June 11, 1957

AP 86 Congress St.—Proposed 3-car masonry
wall garage and Zoning Appeal relating
to the location of it

Building permit for construction of a 3-car one-story concrete block garage about 28 feet by 36 feet for the storage of three motor vehicles (one of which may be a commercial vehicle) (the proposed garage is intended to take the place of a much larger building which would be demolished) is not issuable under the Zoning Ordinance because:

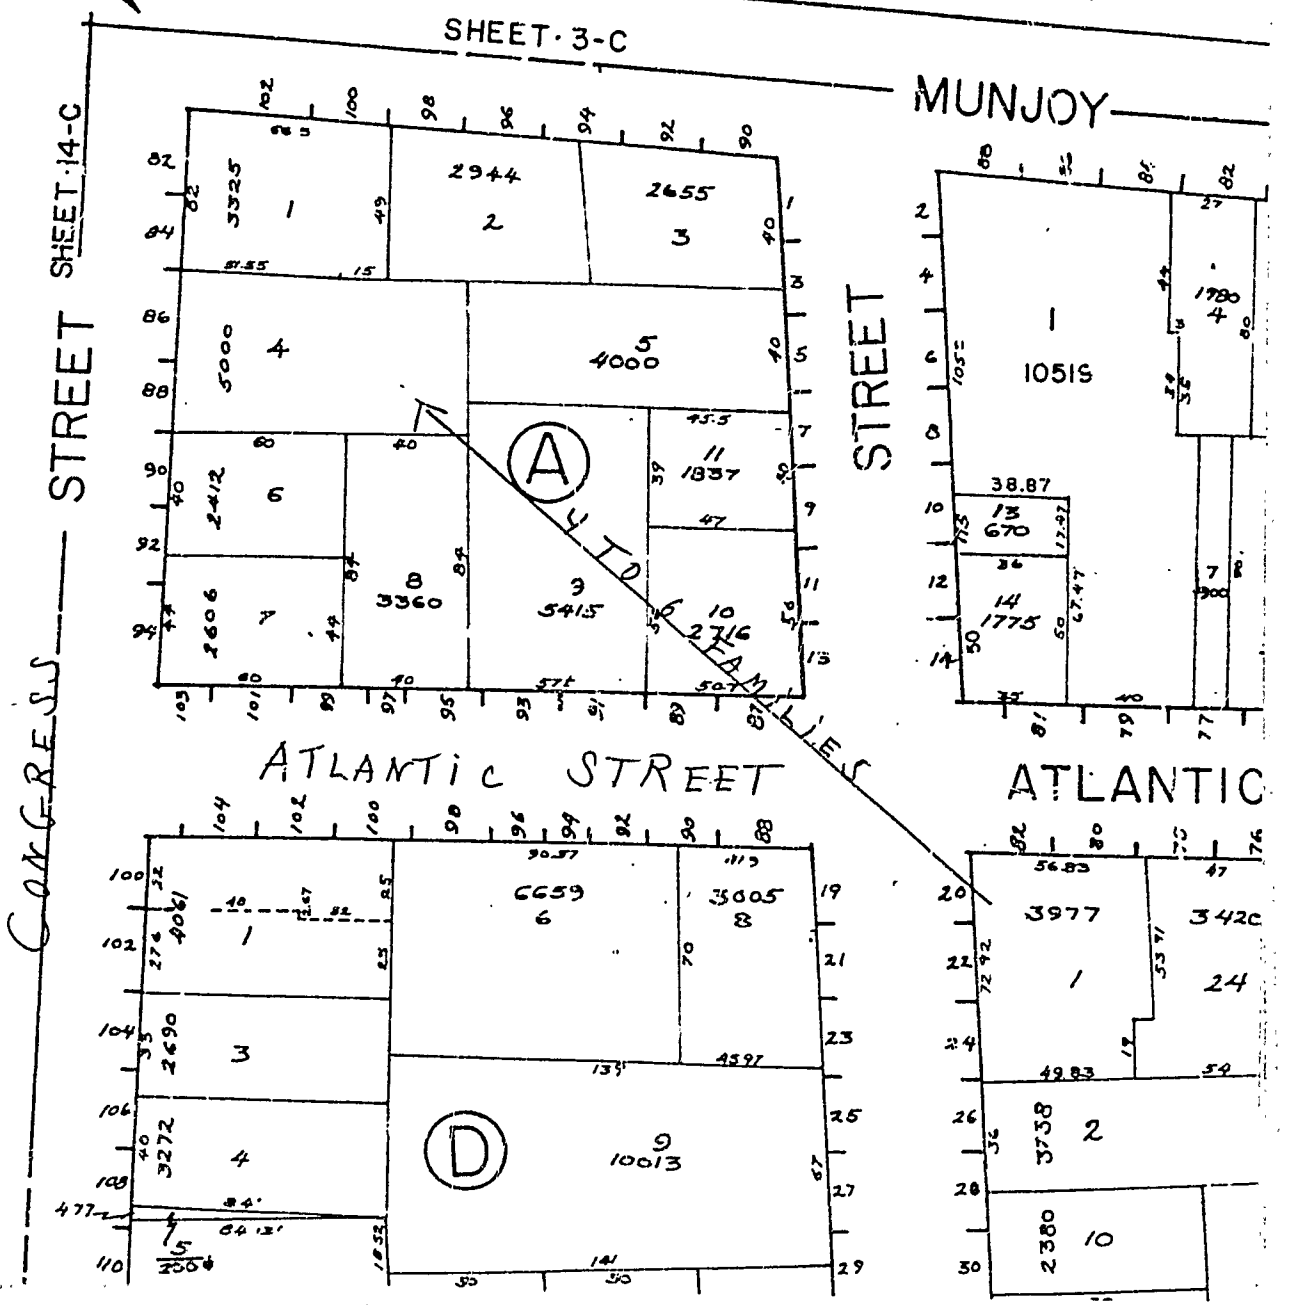
- the rear wall and the side wall toward Atlantic St. would be only one foot from the rear and side property lines, respectively, instead of the 3 feet stipulated by Section 7B 1 and 2 of the Ordinance;
- the proposed building in the rear yard would occupy about 1000 square feet of that yard instead of the 600 square feet limit imposed by Section 10;
- the proposed building together with the existing apartment house on the lot would occupy an area of about 2540 square feet instead of the maximum allowed area of 2000 square feet, the latter figure representing 40% of the area of the lot stipulated by Section 7B 7;

1. A clearance of not less than three feet from side and rear lot lines instead of the one foot distances shown.
2. Only 30% of the approximately 2000 square feet area of the rear yard or about 600 square feet can be occupied by an accessory building instead of the approximately 1000 square feet which proposed building would occupy.
3. Only 40% of the 5050 square feet area of lot or 2020 square feet can be occupied by principal and accessory buildings instead of the approximately 2540 square feet which would be occupied.
4. The proposed building would have to be kept at least five feet away from the dwelling unless attached to it, instead of the separation of about three feet indicated.
